Hampshire Water Transfer and Water Recycling Project

Draft Statement of Common Ground - Hampshire County Council

PLANNING INSPECTORATE SCHEME NUMBER: WA010002

May 2026

Drawing Number
PC5223-RHD-ES-ZZ-D-Z-0015

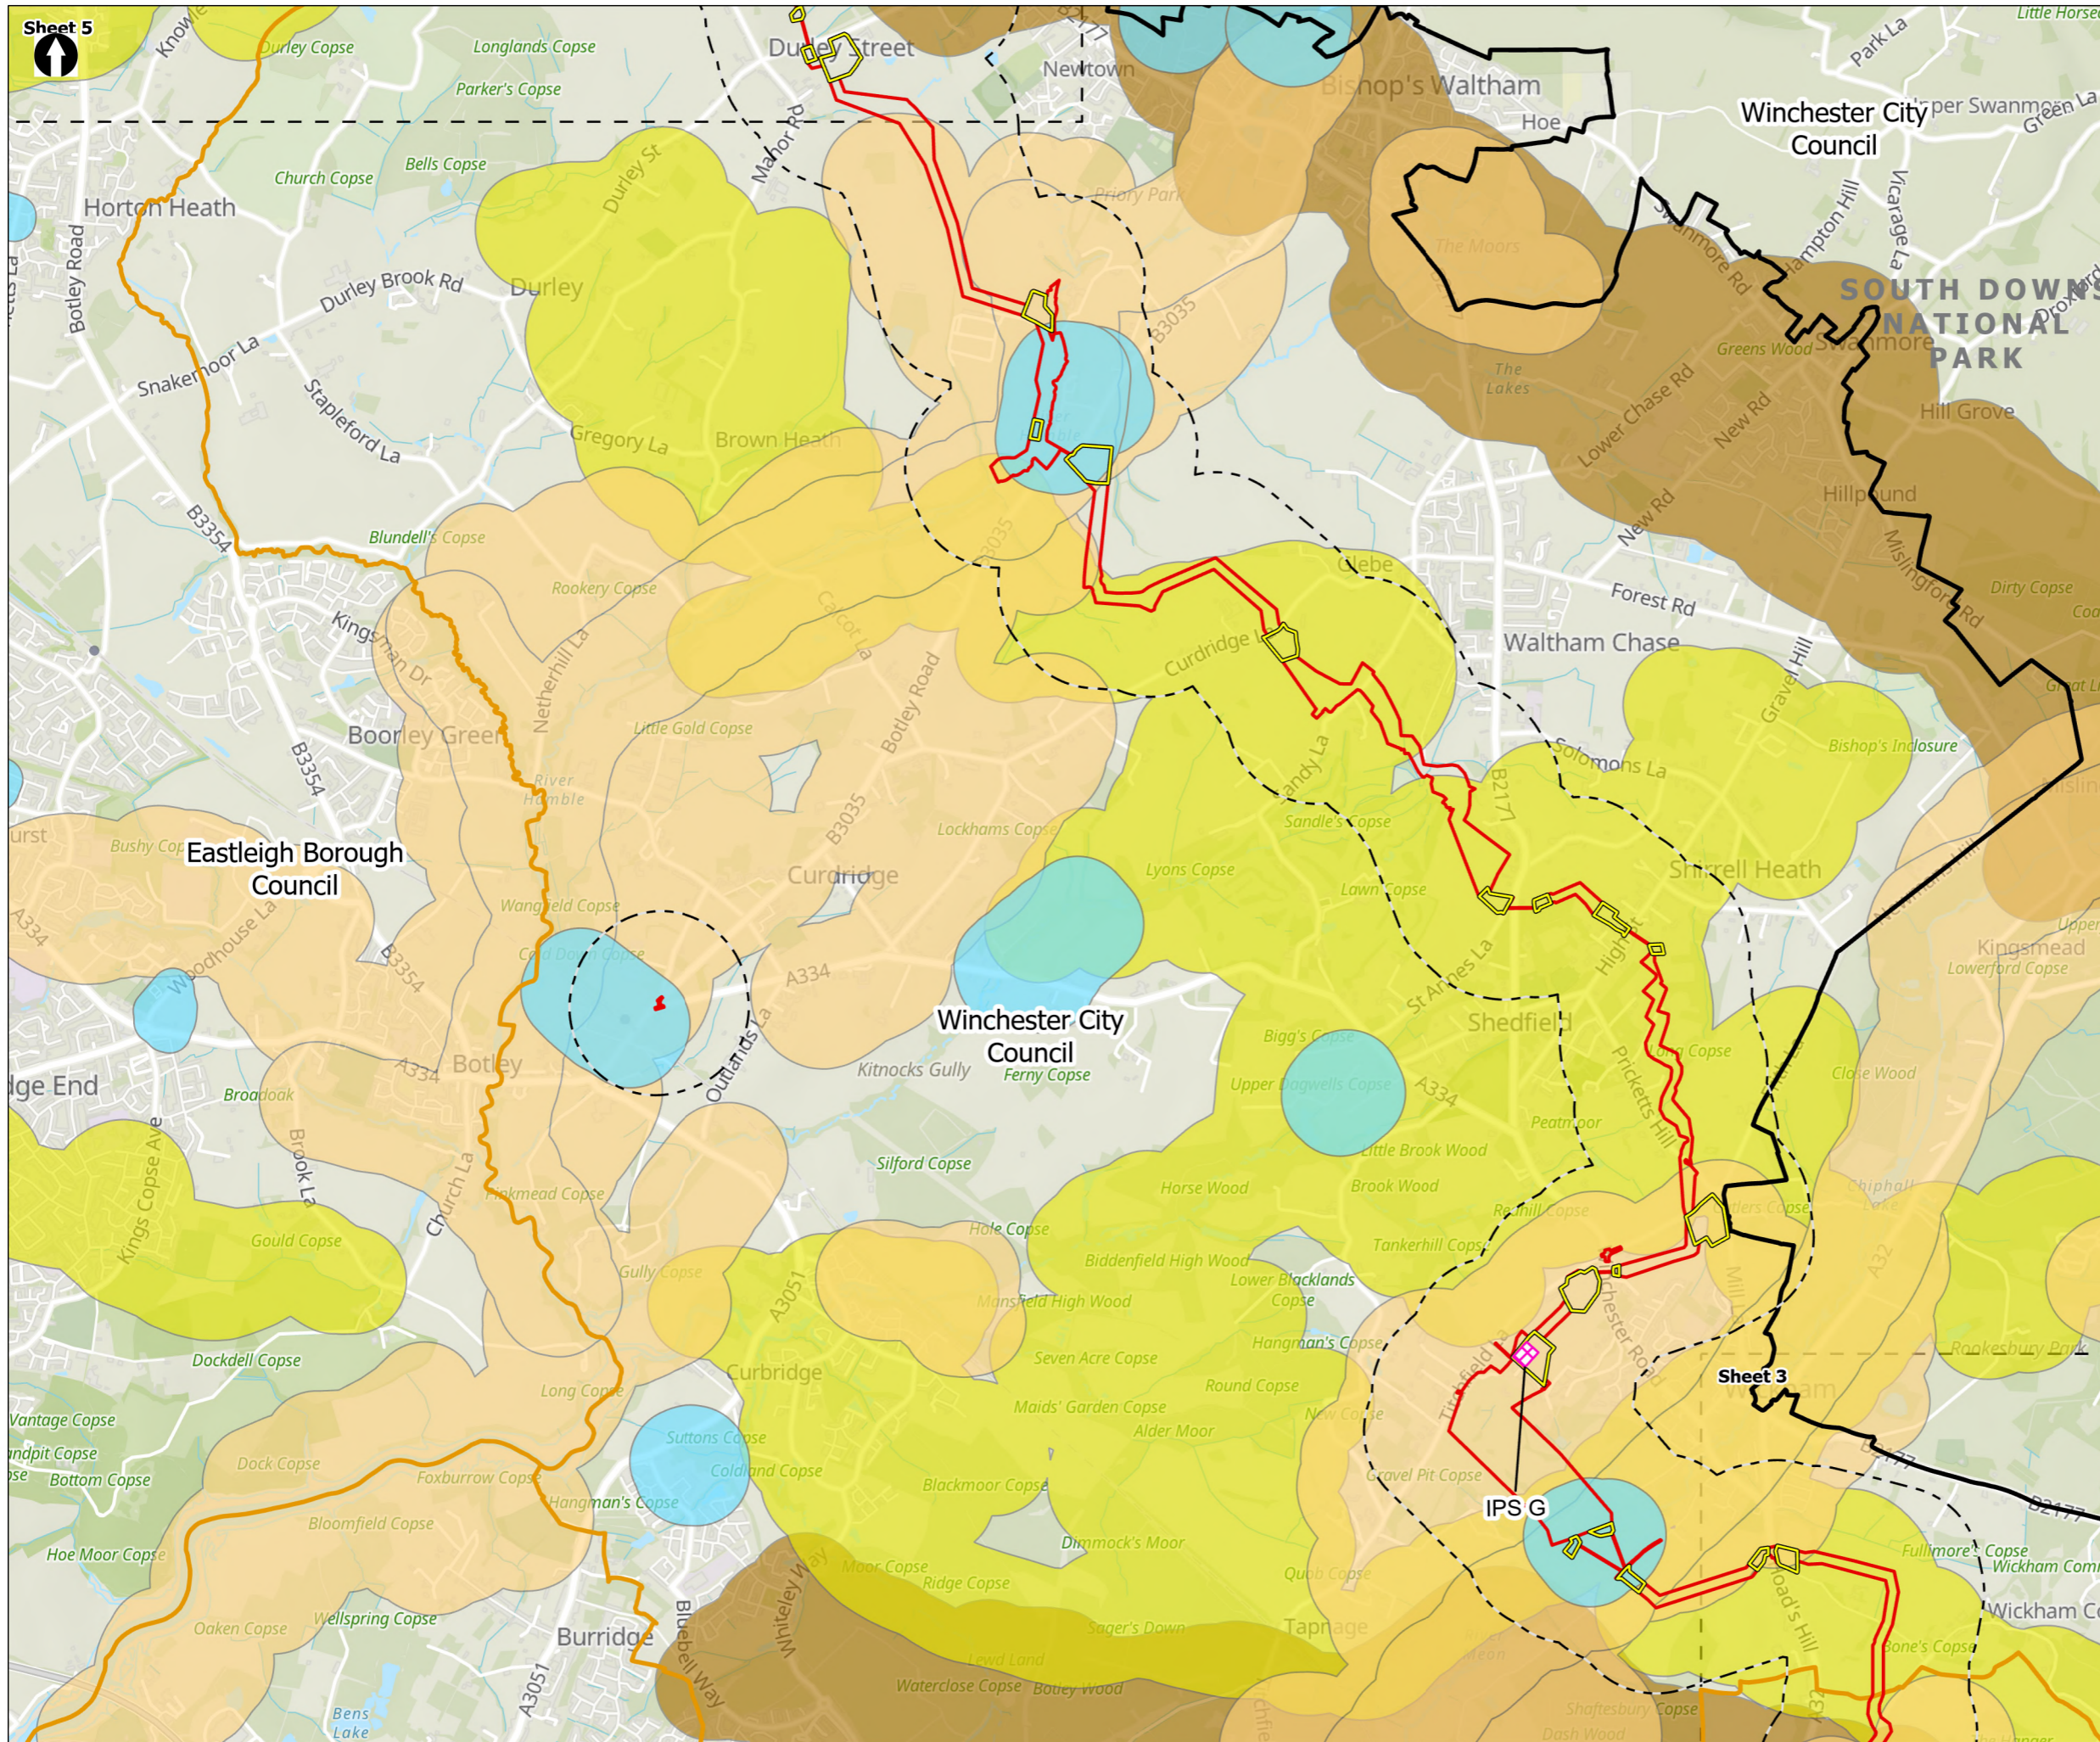
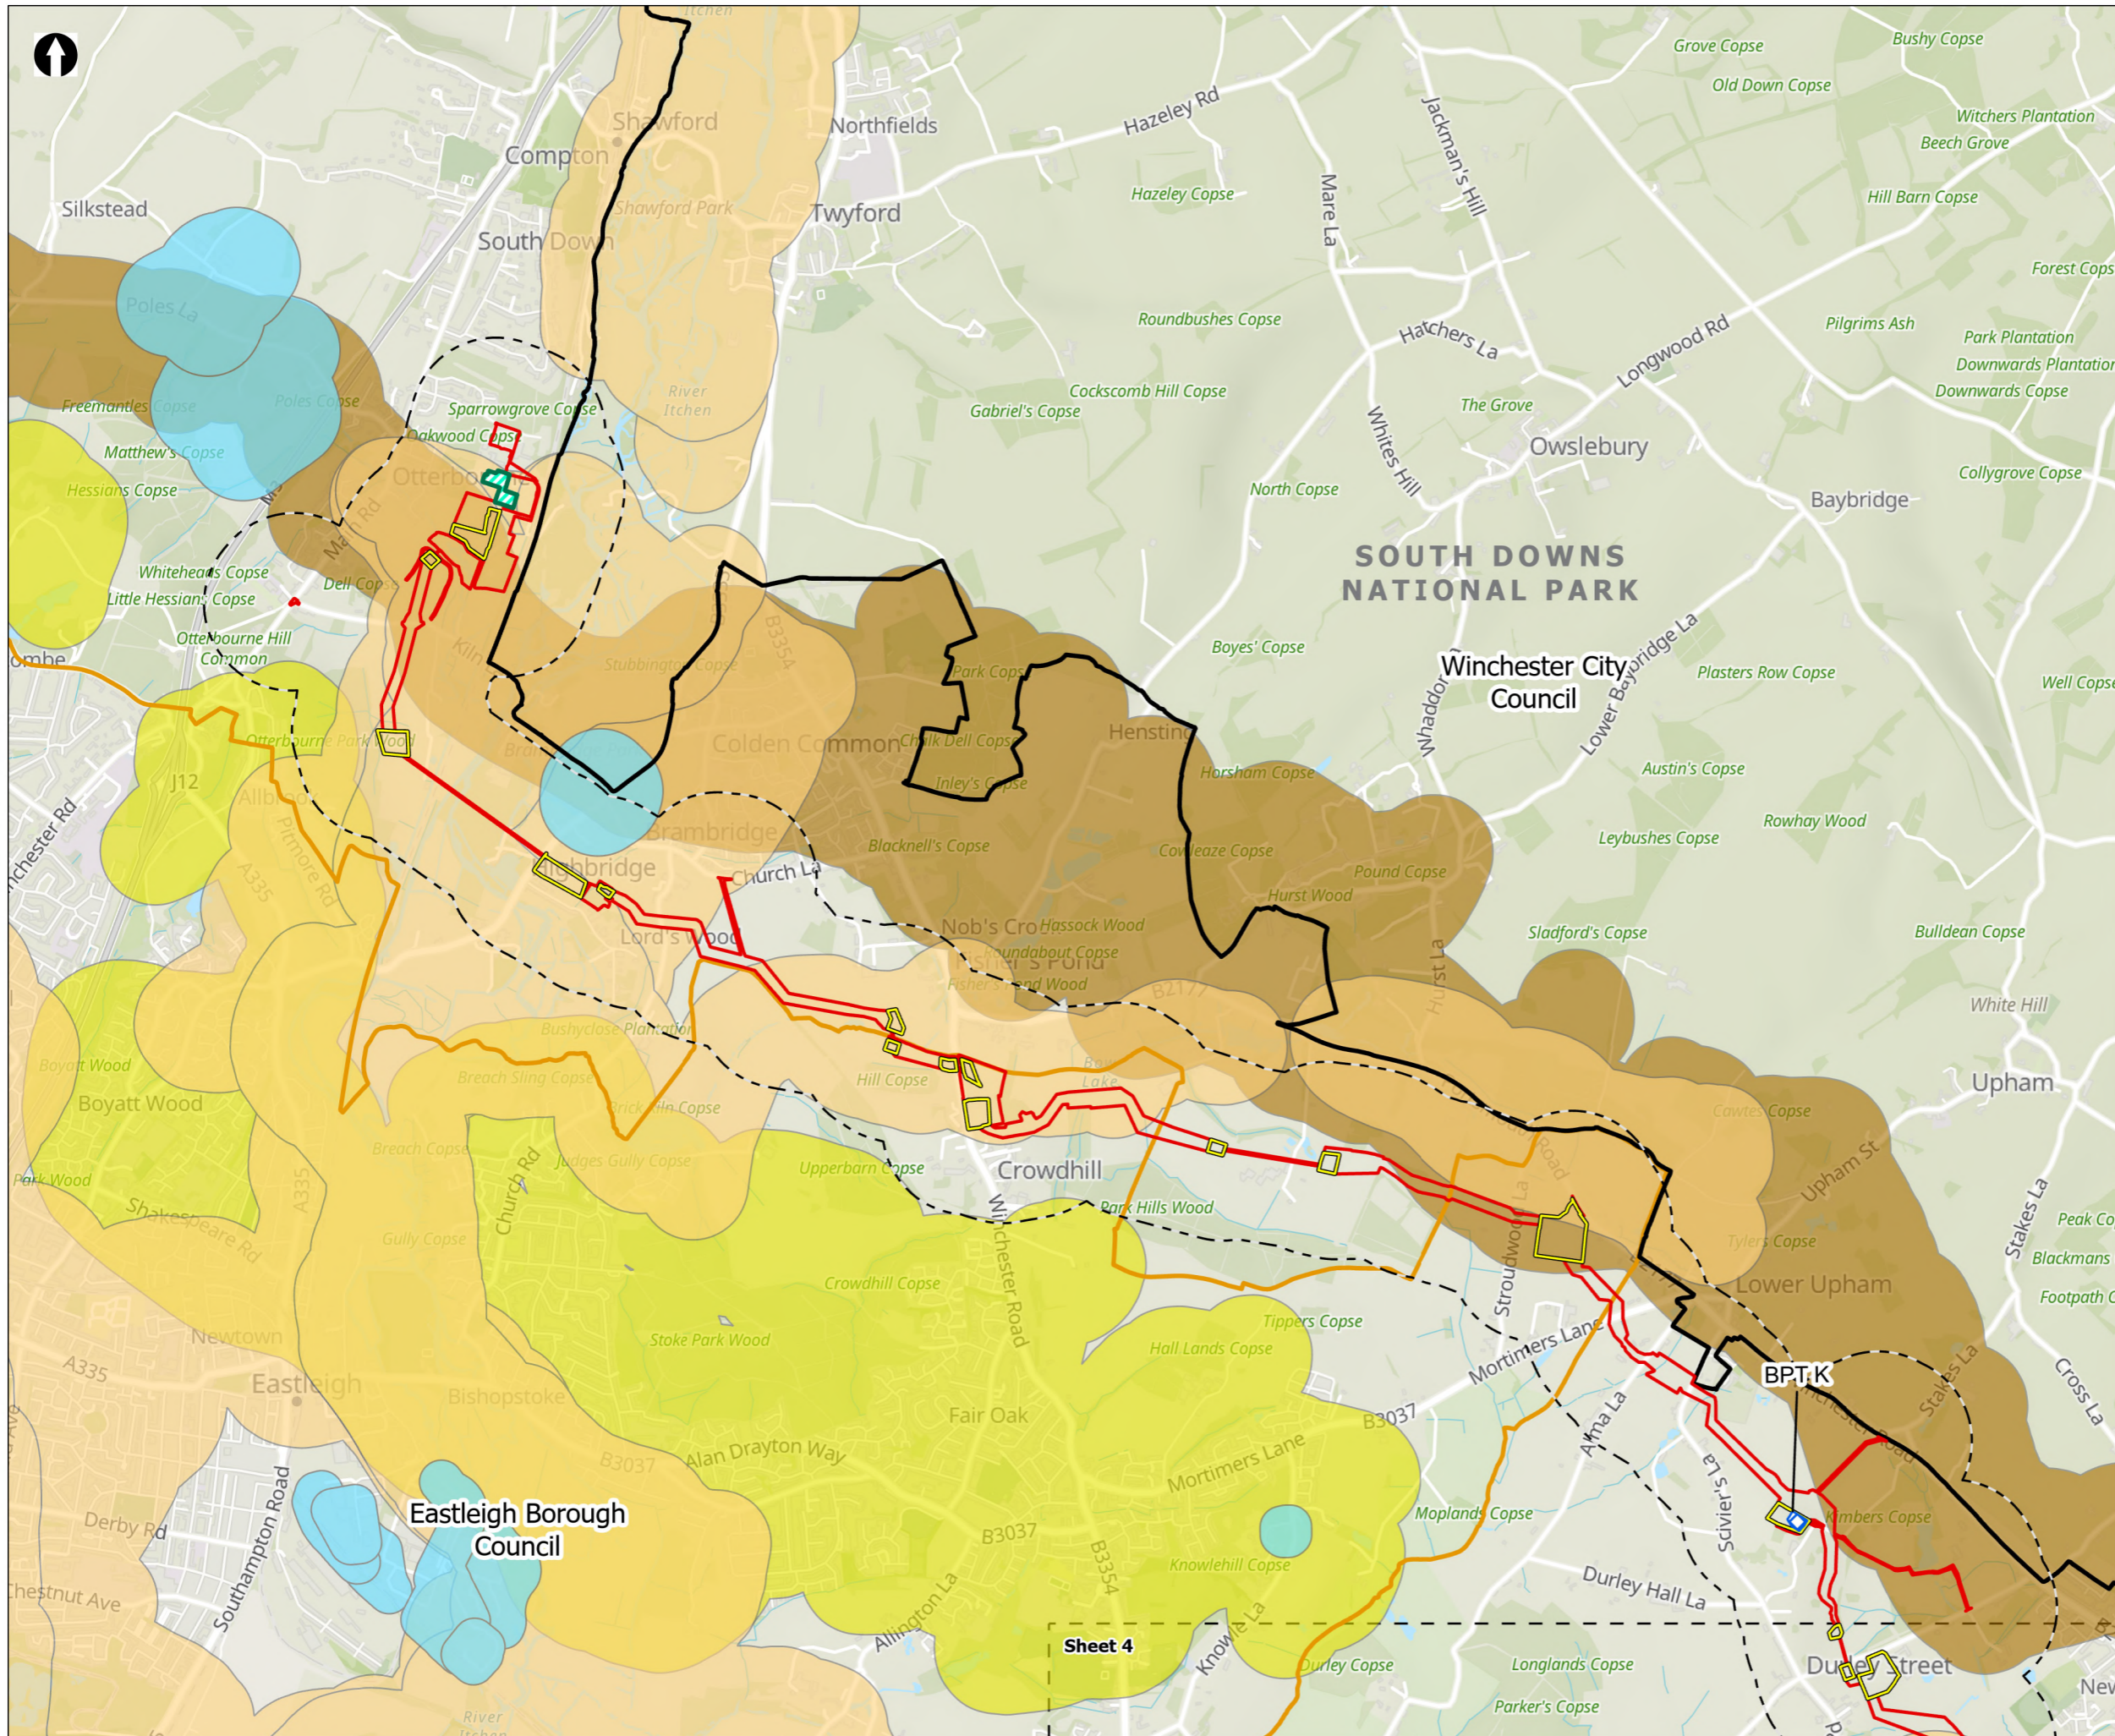
HCC-2022-0064	Resources and waste management - baseline	It is acknowledged that the 100 metres buffer is applied specifically around residential properties in accordance with the Supplementary Planning Document Minerals and Waste Safeguarding in Hampshire adopted in February 2016.	The Applicant acknowledges the HMWPA's position.		Matter agreed with other party.
HCC-2024-0189	Resources and waste management - baseline	The HMWPA supports the prior extraction of soft sand from Five Oaks Farm, in principle, to prevent sterilisation. The onus is on the landowner to pursue agreement with the developer to resolve the issue of the development of sand extraction at the Five Oaks Site, as well as the appropriate permissions from the HMWPA - but continue to bear in mind soft sand resource safeguarding and sterilisation policies of the HMWP (2013) and the emerging HMWP update.	The HMWPA supports the prior extraction of soft sand from Five Oaks Farm, in principle, to prevent sterilisation. The onus is on the landowner to pursue agreement with the developer to resolve the issue of the development of sand extraction at the Five Oaks Site, as well as the appropriate permissions from the HMWPA - but continue to bear in mind soft sand resource safeguarding and sterilisation policies of the HMWP (2013).	ES Appendix 16.1 Mineral Safeguarding Assessment, Volume II (Document reference 6.2, DCO Volume 6).	Matter agreed with other party.

HCC-2024-0159	Resources and waste management - assessment	The HMWPA supports the structured approach to assessing regional waste capacity impacts in the ES. HMWPA understands and is satisfied that the Outline CEMP (Document reference 7.1, DCO Volume 7) includes measures to produce, implement and maintain a Site Waste Management	The Applicant acknowledges the HMWPA's position.	Outline Construction Environmental Management Plan (Document reference 7.1, DCO Volume 7). ES Chapter 16 Resources and waste management, Volume I (Document	Matter agreed with other party.

HCC-2025-SC-0027	Resources and waste management - mitigation	The HMWPA notes that design refinement 24 - From Mortimers Lane (B3037) near Lower Upham to Highbridge Road (B3335), west of Brambridge, will have minimal effect on how much of the pipeline easement is within the Mineral Safeguarding Area. The Mineral Resource Assessment (MRA) will be required to understand the Applicant's assessment of how to deal with extracted minerals.	The Applicant has prepared an Appendix 16.1 Mineral Safeguarding Assessment, Volume II (Document reference 6.2, DCO Volume 6) accompanying the ES Chapter 16 Resources and waste management, Volume I (Document reference 6.1, DCO Volume 6) in response to the proportion of the land within the Order Limits coinciding with the Mineral Consultation Areas (MCA) as identified by HCC in its adopted Hampshire Minerals and Waste Plan. The Outline CEMP (Document reference 7.1, DCO Volume 7) requires the Contractor to develop a Minerals Management Strategy (MMS) as part of the	ES Appendix 16.1 Mineral Safeguarding Assessment, Volume II (Document reference 6.2, DCO Volume 6). ES Chapter 16 Resources and waste management, Volume I (Document reference 6.1, DCO Volume 6). Outline Construction Environmental Management	Matter agreed with other party.
